From: Amanda Scholes on behalf of Planning.Responses
Sent: 19 August 2019 09:00
To: Planning Scanning
Subject: FW: AB/68/19/HH & AB/69/19/L

AB/68/19/HH & AB/69/19/L

Avola House is a late 18th Century Grade II Listed Building which is located within the centre of Arundel. It is a four-storey house on the Northern side of Tarrant Street, at the apex of Bakers Arms Hill. Whilst it appears to be a detached building, it is essentially a semi-detached house, since a separate property is attached to its northern elevation.

EXISTING WEST ELEVATION & SECTION A-A
DATE. June 2019
SCALE. 1:100 @ A3
JOB No. 1070
DRWG No. 107 Rev.

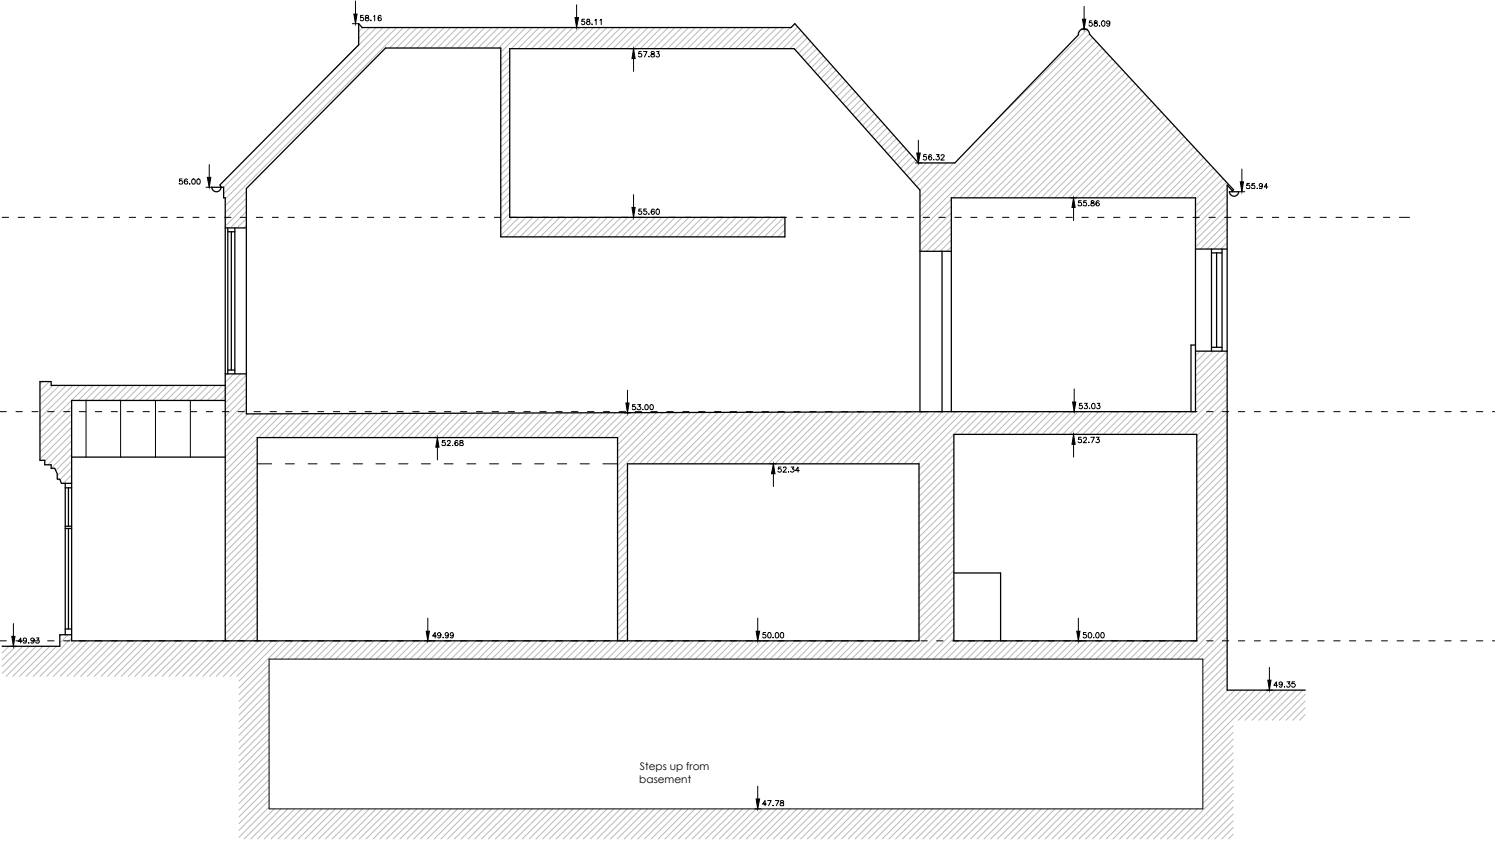
The replacement of the modern feature window to the West elevation at First Floor level will result in a much more appropriate fenestration detail and would enhance the elevations. Such a move will enhance the elevation, and therefore the building.

Work to expose the original brickwork on western elevation will allow an inappropriate material to be removed, the bricks to 'breathe' and the original appearance to be restored. However, there is potential for the works to damage the bricks and therefore the elevation. Works should be carefully carried out by any skilled contractor. You may wish to ask for a method statement in order to ensure that no harm is caused. Likewise, details of the repointing should be provided in order to ensure that the new work replicated the existing.

PROPOSED SECOND FLOOR

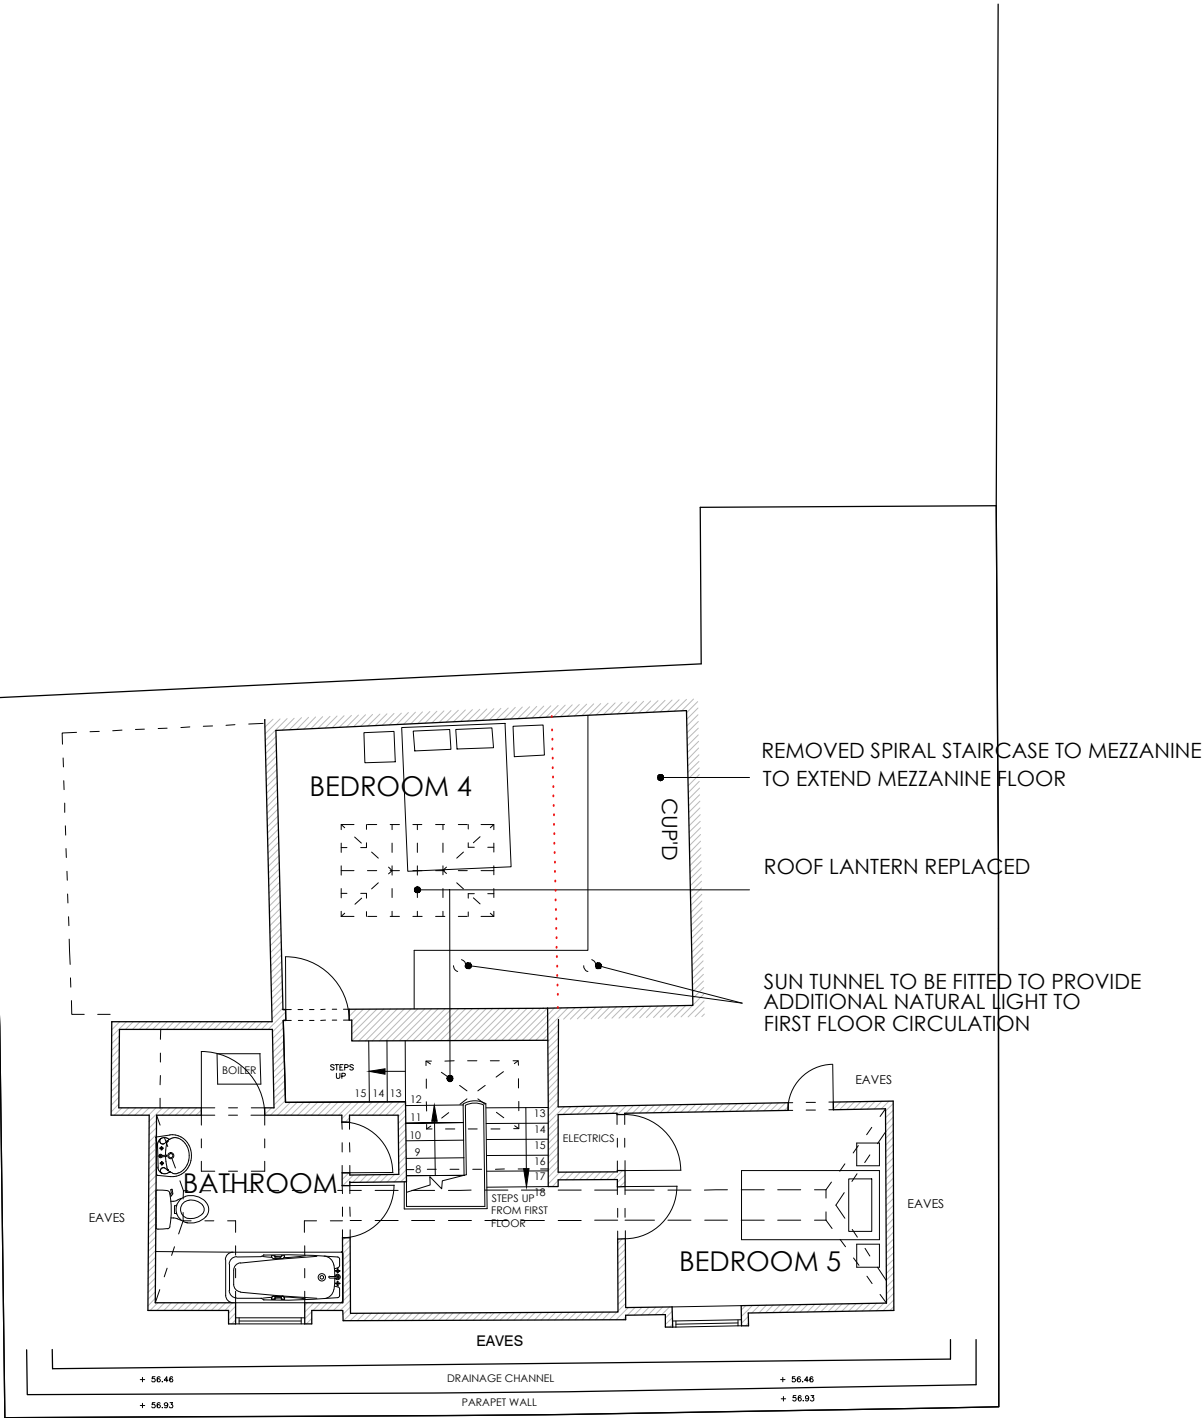
The removal of the spiral staircase and associated works in order to create a bedroom and two bathrooms will remove modern works/fabric which are not considered appropriate for the significance of the building. It will also introduce spaces which are more appropriate for the building.

PROPOSED EXTERIOR STAIR SECTION  
DATE. June 2019  
SCALE. 1:50 & 1:20 @ A3  
JOB No. 1070  
DRWG No. 119 Rev.

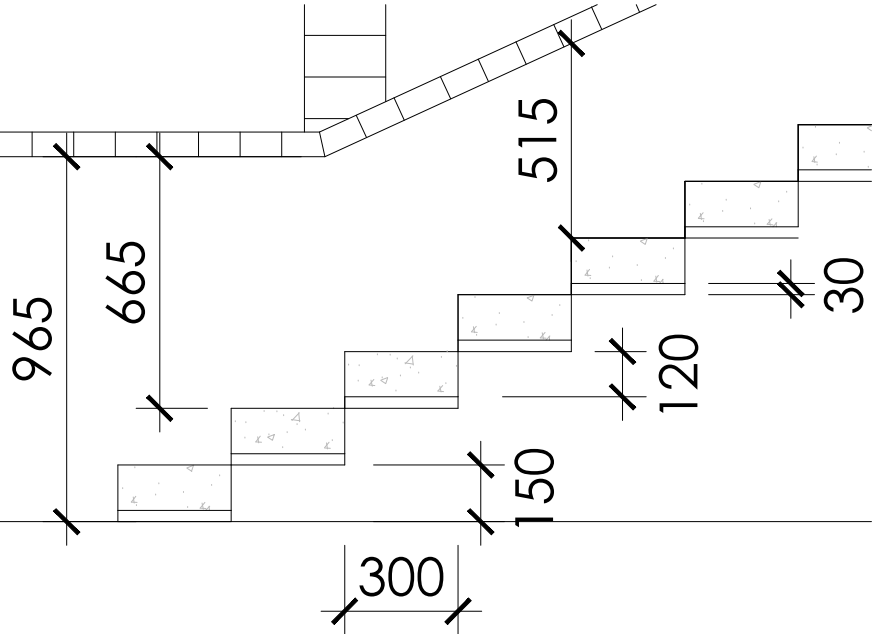
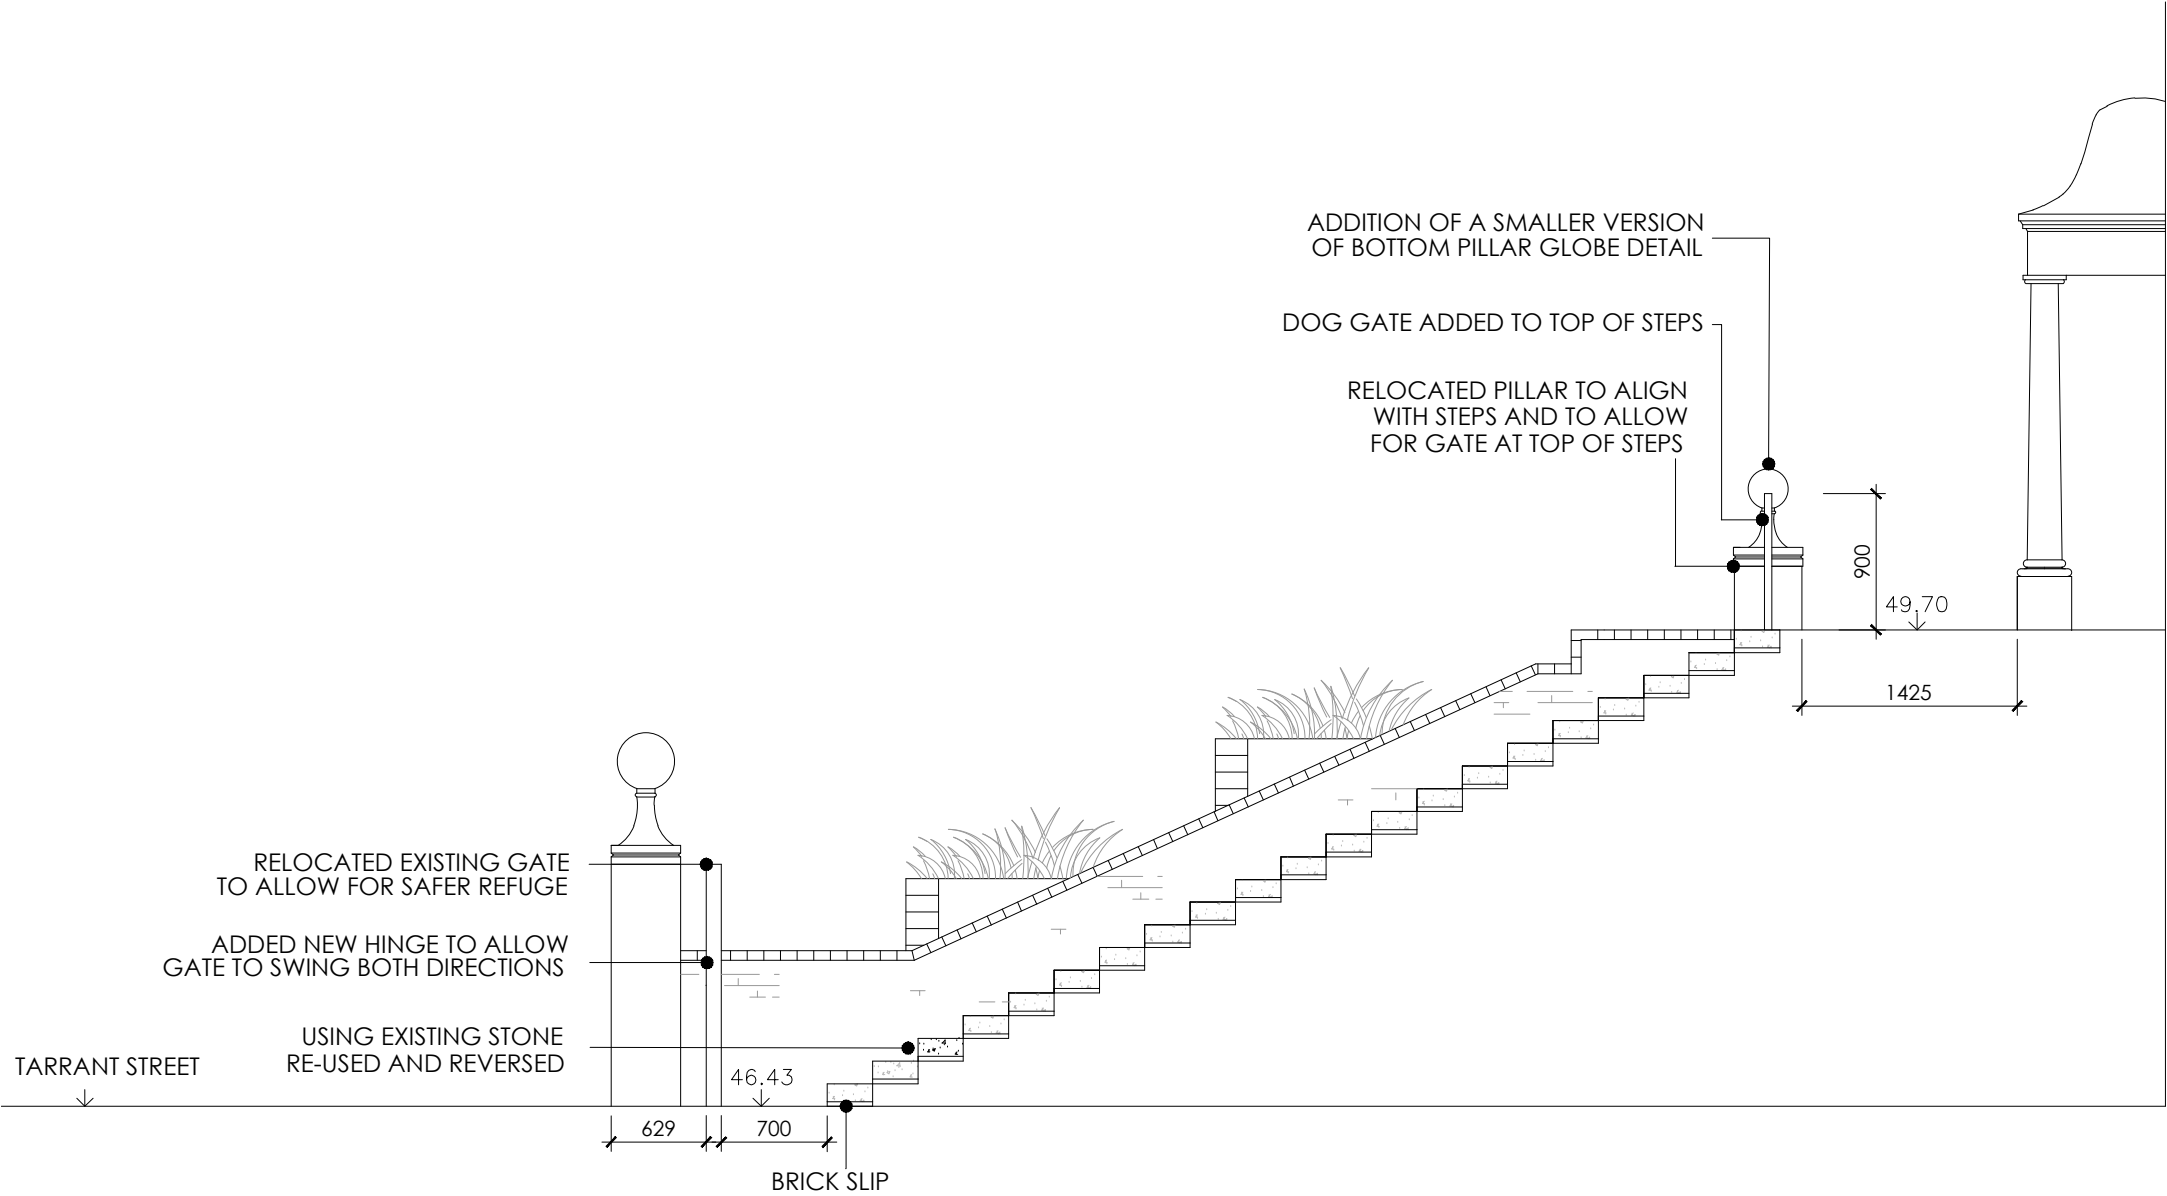
The reconstruction of the damaged external steps and the creation of a refuge at street level to allow for safe access from Tarrant Street seems to be an acceptable approach. However, I note from the listing description that some of the steps include a local stone (Bognor Rock). This material should be incorporated within the design in a similar way/appearance. Such an approach should be confirmed.
